Our Ref: LU/162/19/CLP
Your Ref:

Application for Lawful Development Certificate for a Proposed Use or Development

Development Lawful development certificate for a proposed ground floor side extension, ground & first floor rear extension, rear dormer & front roof windows.

Location Parkfield Worthing Road Littlehampton

PROPOSED SITE/BLOCK PLAN 1:500

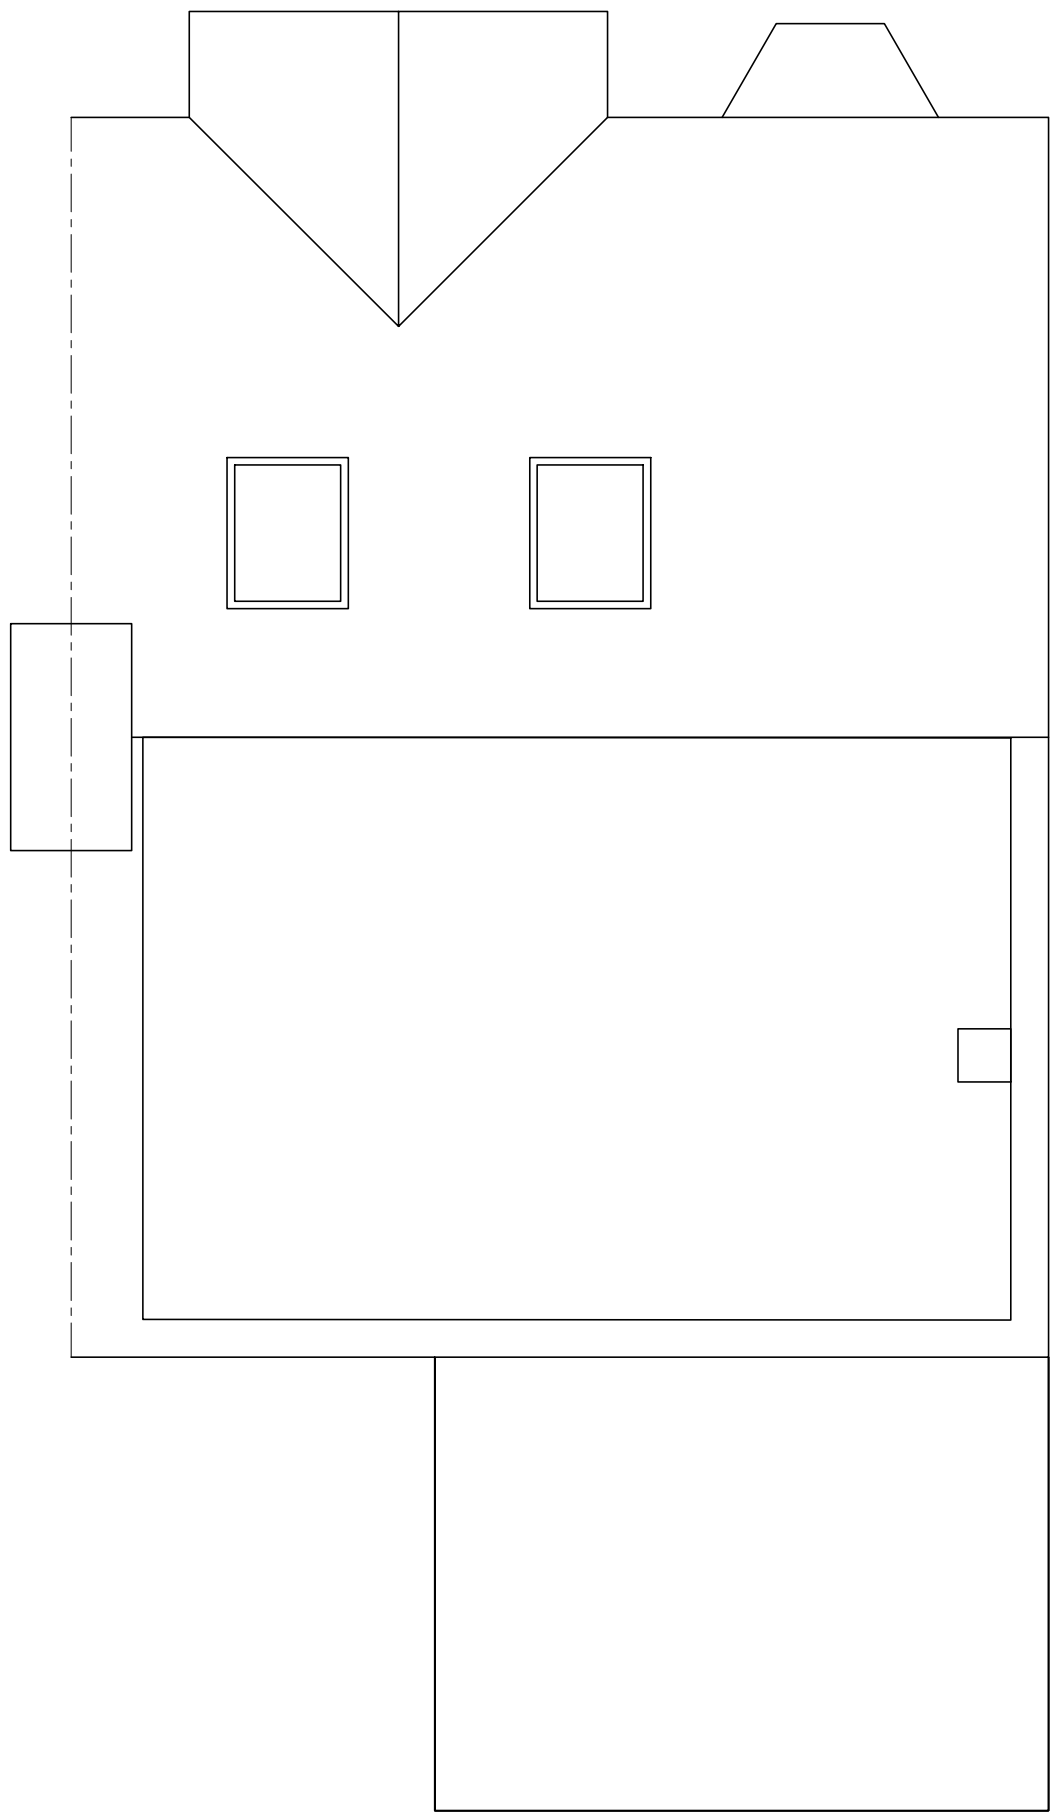
Please amend the Proposed Site/Block plan to show the dimensions to all boundaries.
